M60/M62/M66 Simister Island – TR010064

Section 51 advice regarding draft application documents submitted by National Highways

The advice recorded in the table below relates solely to matters raised upon the Planning Inspectorate's review of the draft application documents listed above. The advice is limited by the maturity of the documentation provided by the Applicant and the time available for consideration and is raised without prejudice to the acceptance decision or the final decision about whether development consent should be granted.

FIGURE 2.4

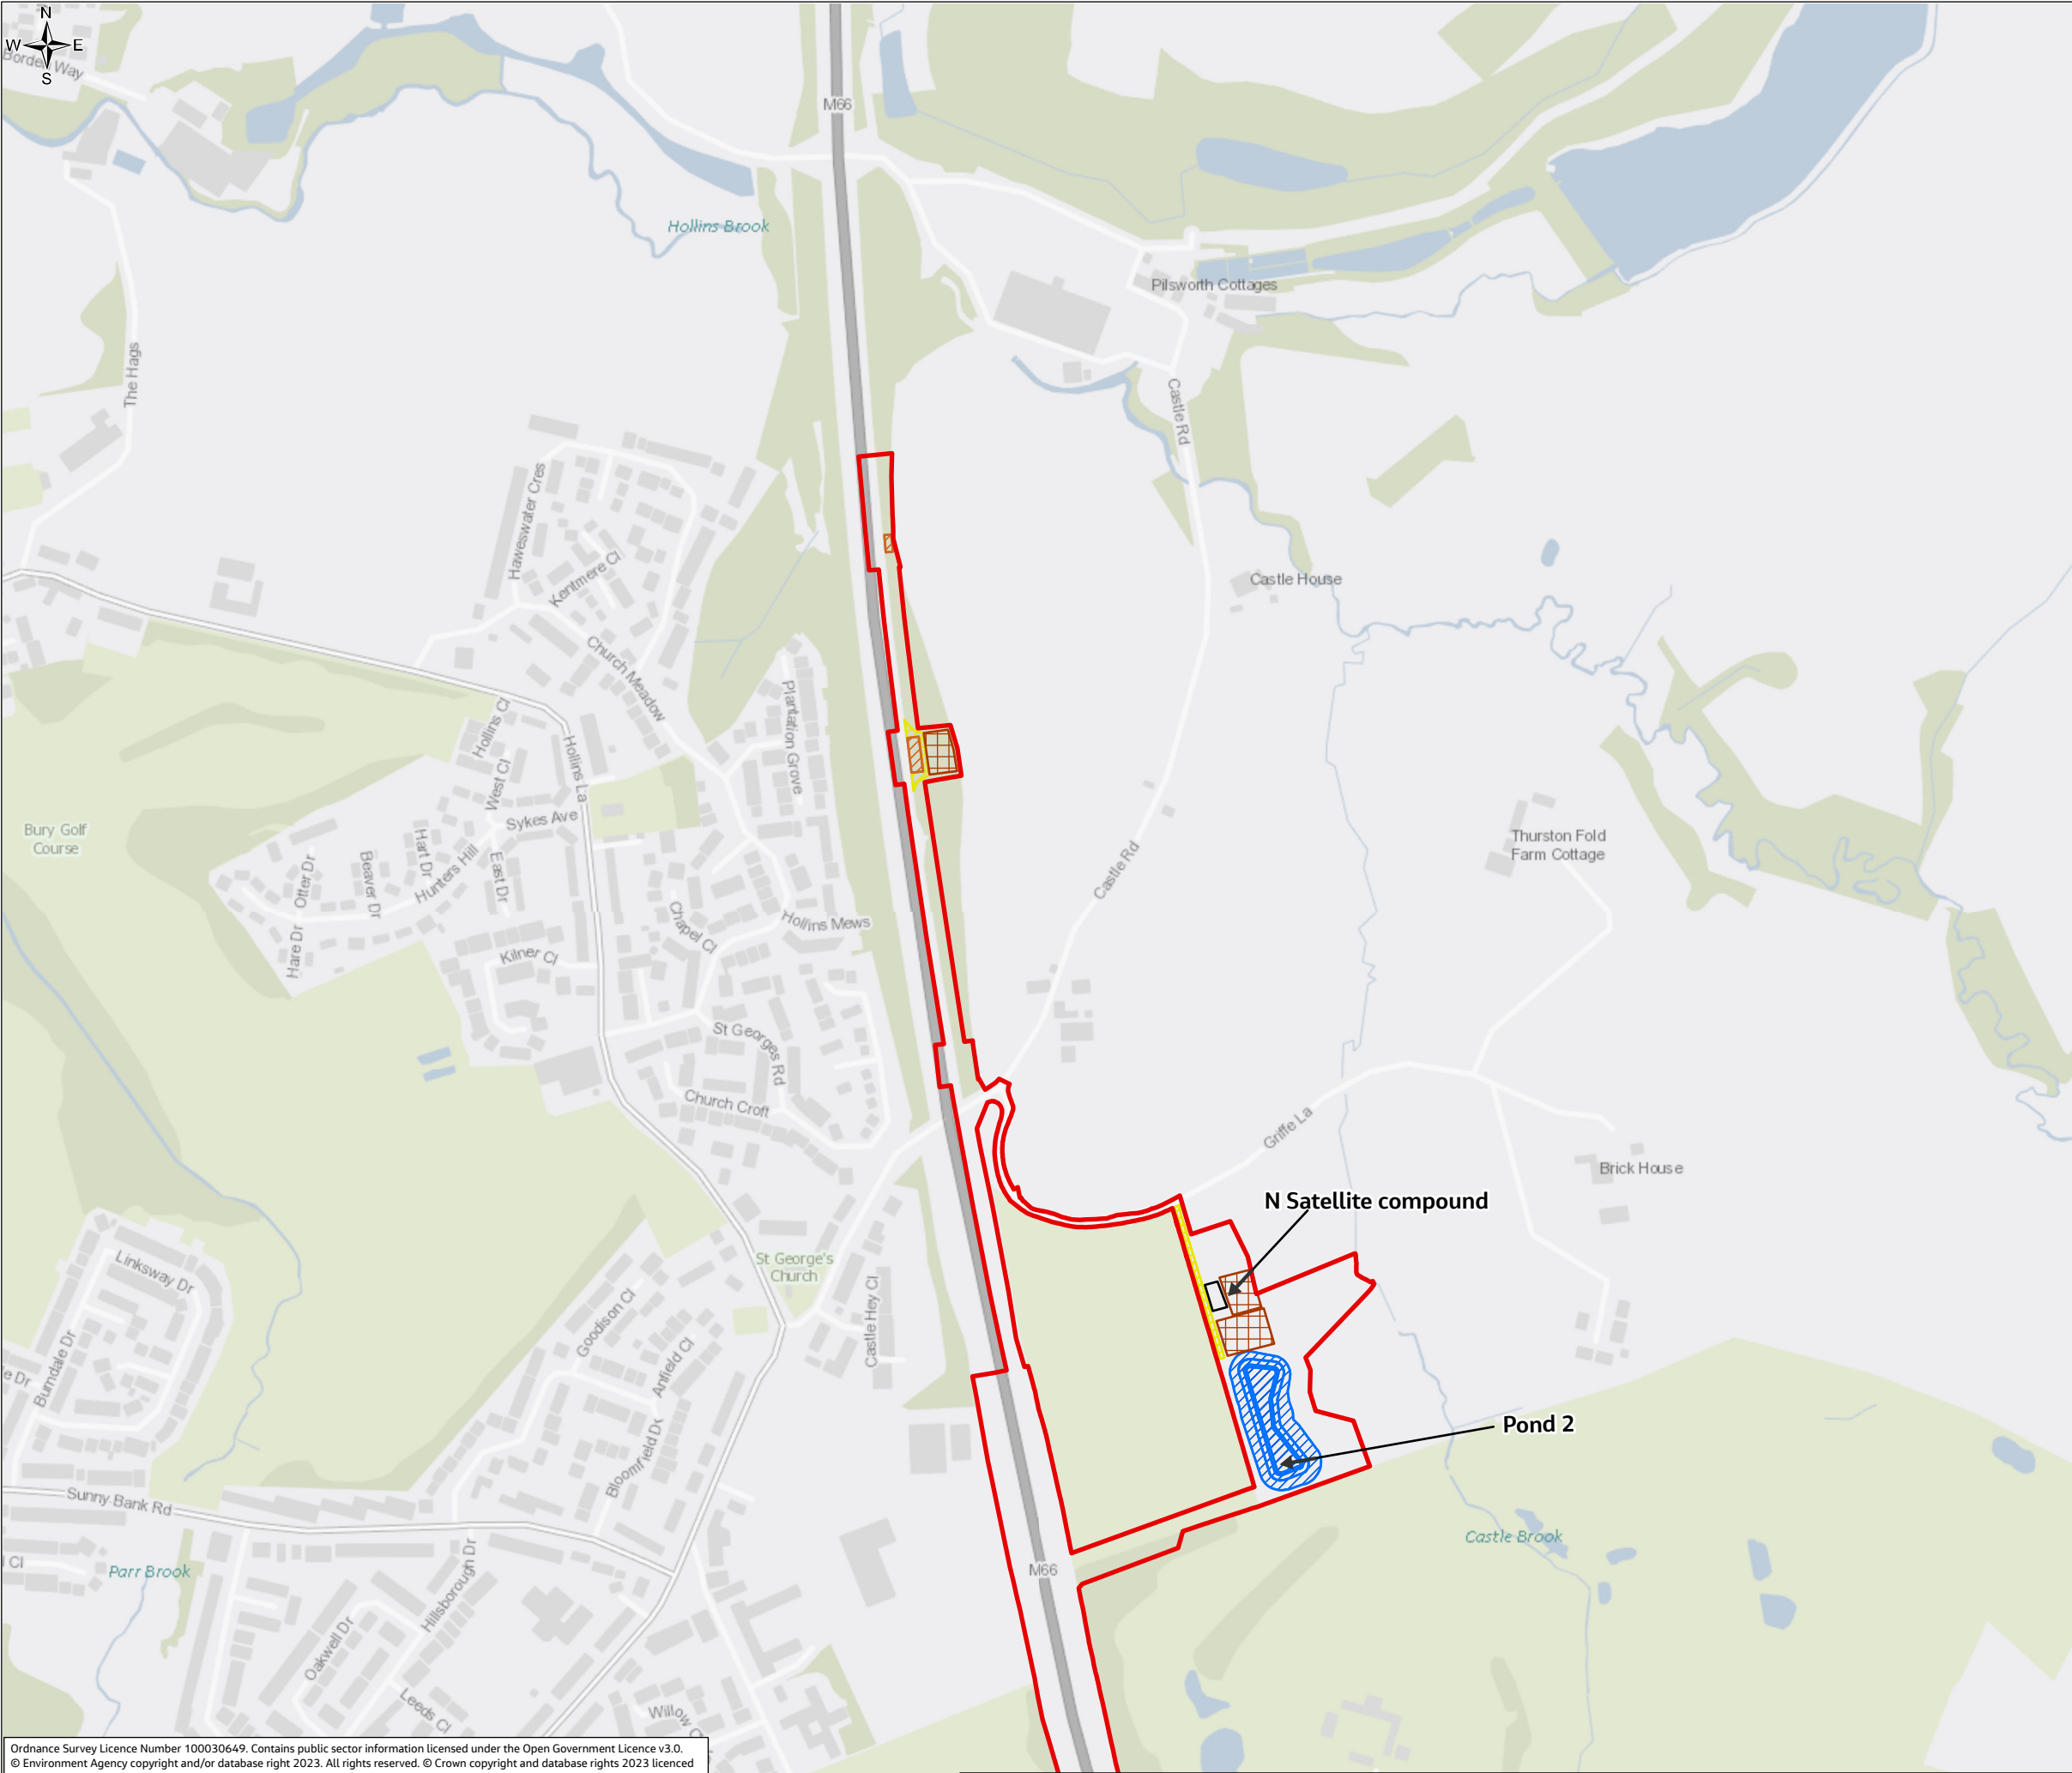
21.	2.5.82 and ES Figure 2.4	ES Figure 2.4 depicts several stockpile areas. These have not been described within ES Chapter 2. The Applicant should ensure that all elements of the Proposed Development are captured within ES Chapter 2 and ensure consistency between documents.
